Date: 30 January 2019
Your reference: MP10_0046 MOD 4
Our reference: DOC19/66112
Contact: Calvin Houlison
4224 4179

RE: Russell Vale Colliery Modification 4 (MP 10_0046 MOD 4) Response To Submissions

Attachment A: OEH Detailed Comments on Russell Vale Colliery Modification 4 (MP 10_0046 MOD 4)

APPENDIX F
PROPOSED SCENARIO FLOOD MAP

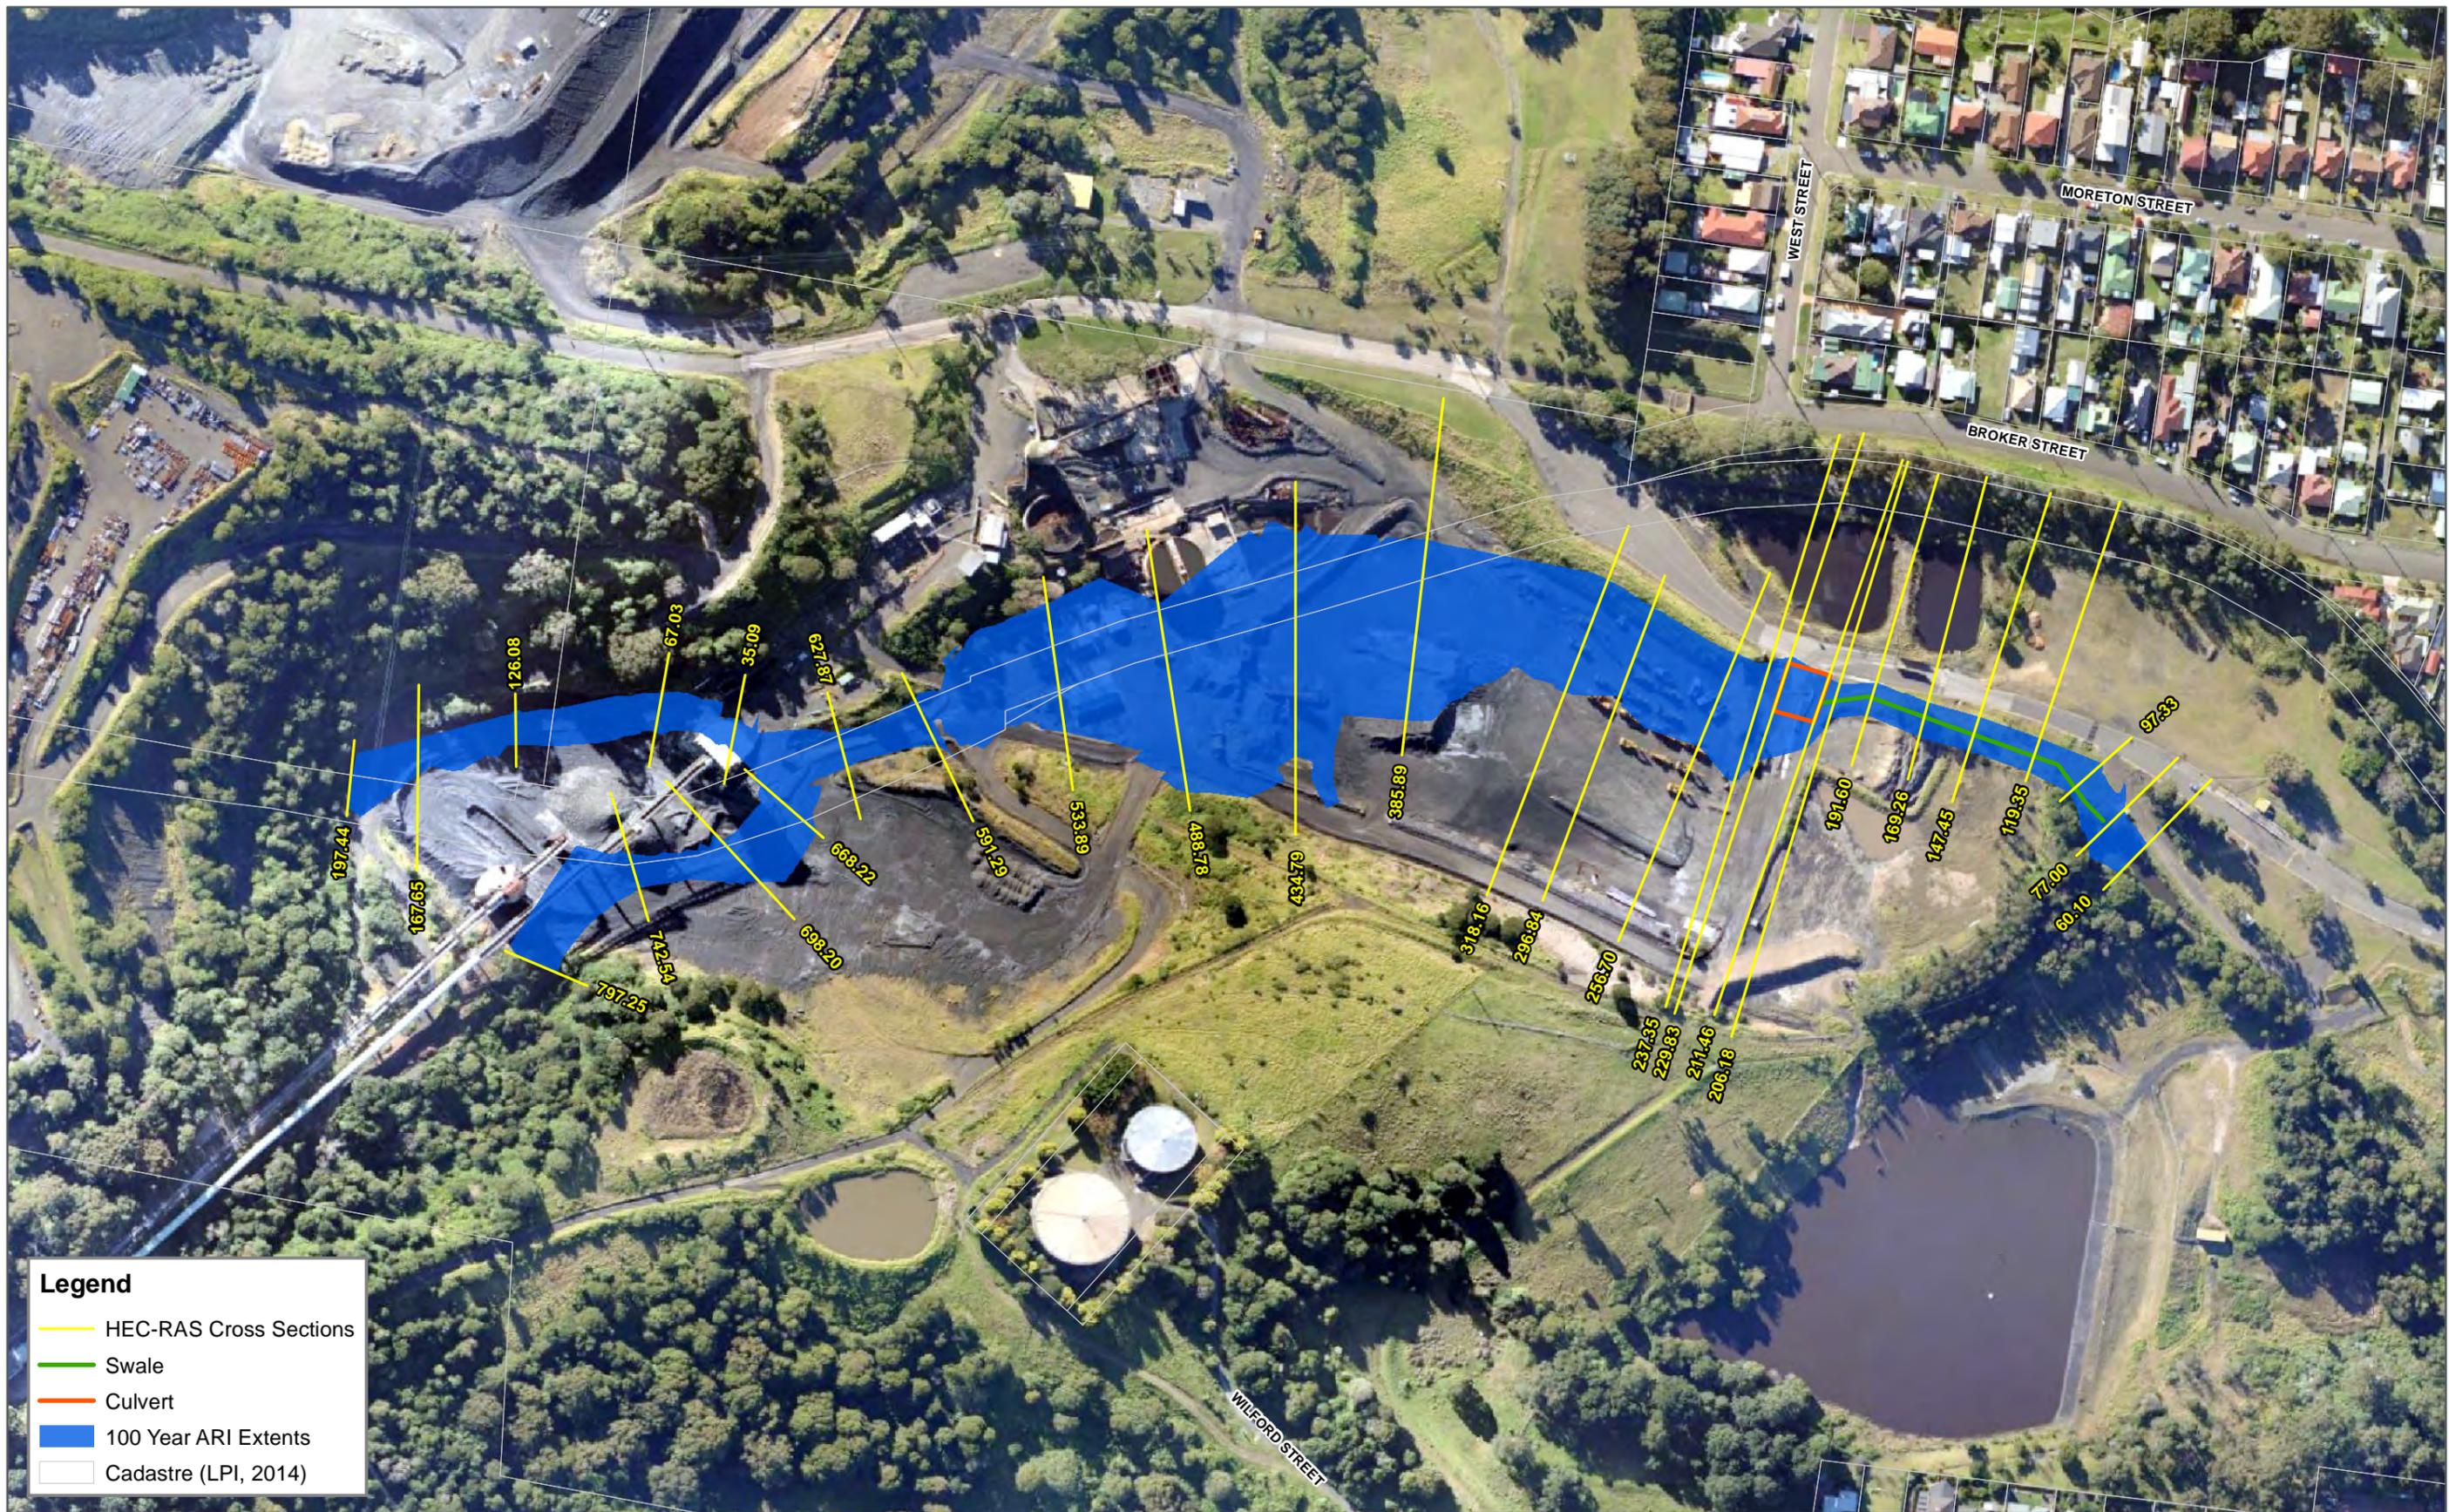
- The report contends that the Cardno (2015) approach is unsuitable due to increases in peak flows at the Princes Highway. This is contrary to results provided which included a refined sediment basin (as per Cardno (2015) recommendation) to prevent bypass of dirty water flows. The flood impact map of the Cardno (2015) approach with refined basin shows flood level reductions at downstream locations.

APPENDIX G
PROPOSED MITIGATION STRUCTURES

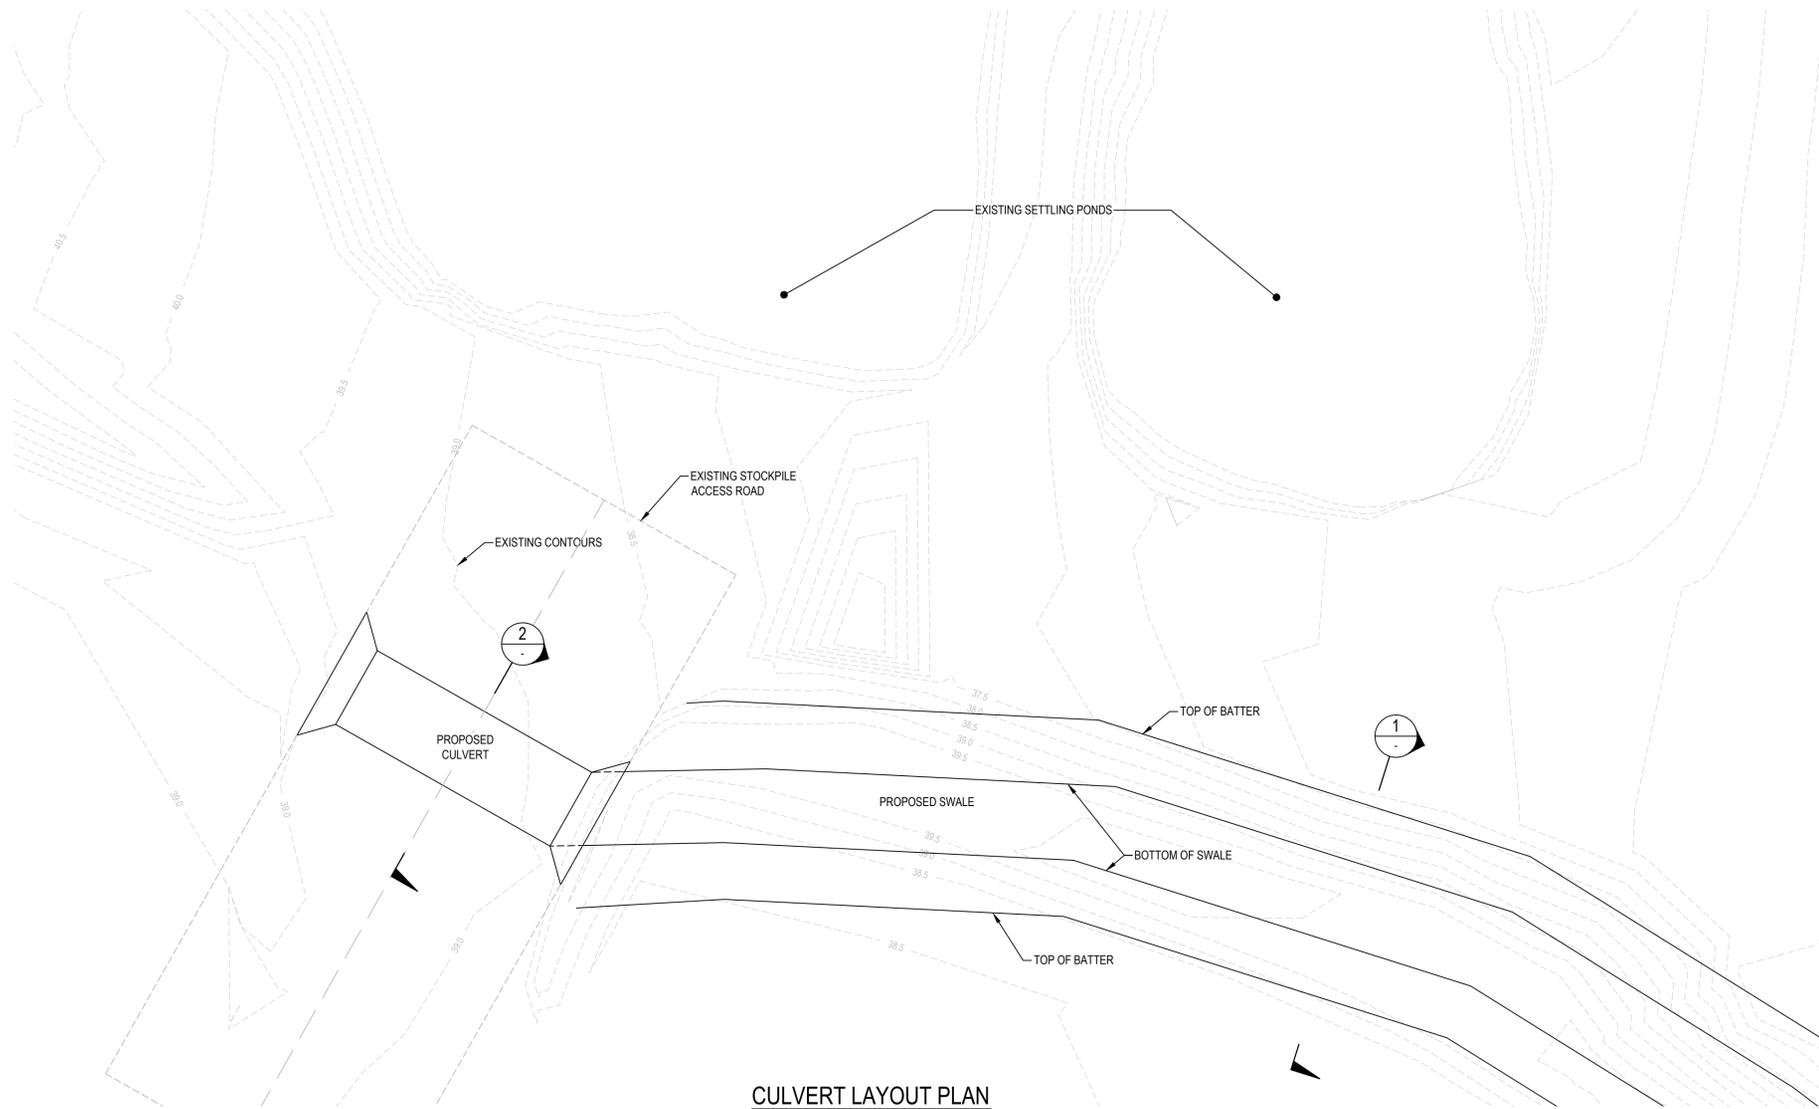
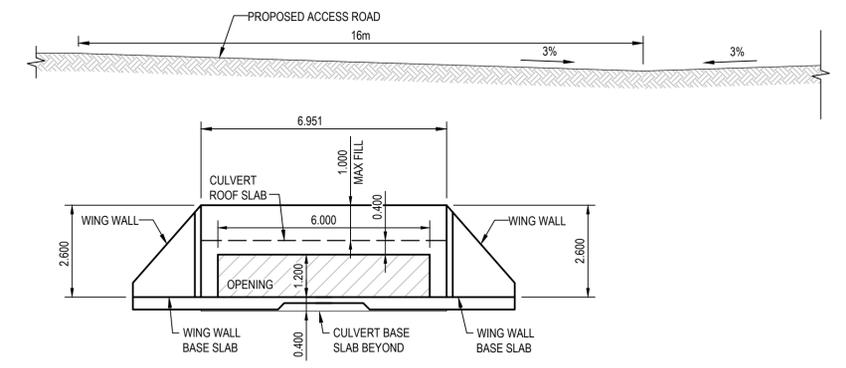
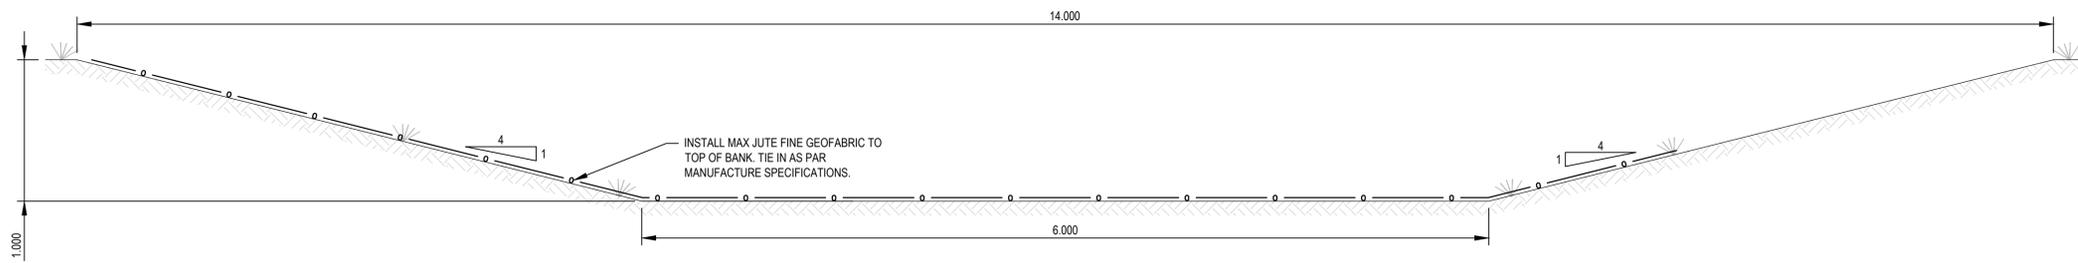
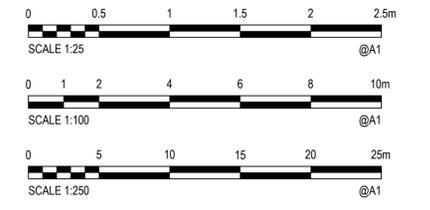
- The assessment concludes that the culvert, swale and access road upgrades proposed by Cardno (2015) are not required. However, it is understood these measures were put in place to off-set the impact of uncontrolled and untreated flows from the site. It is therefore unclear whether incorporation of these elements (or a refinement of them considering revised modelling, survey and blockage assumptions) into the proposed approach would be more effective in minimising or preventing overflows from the site.
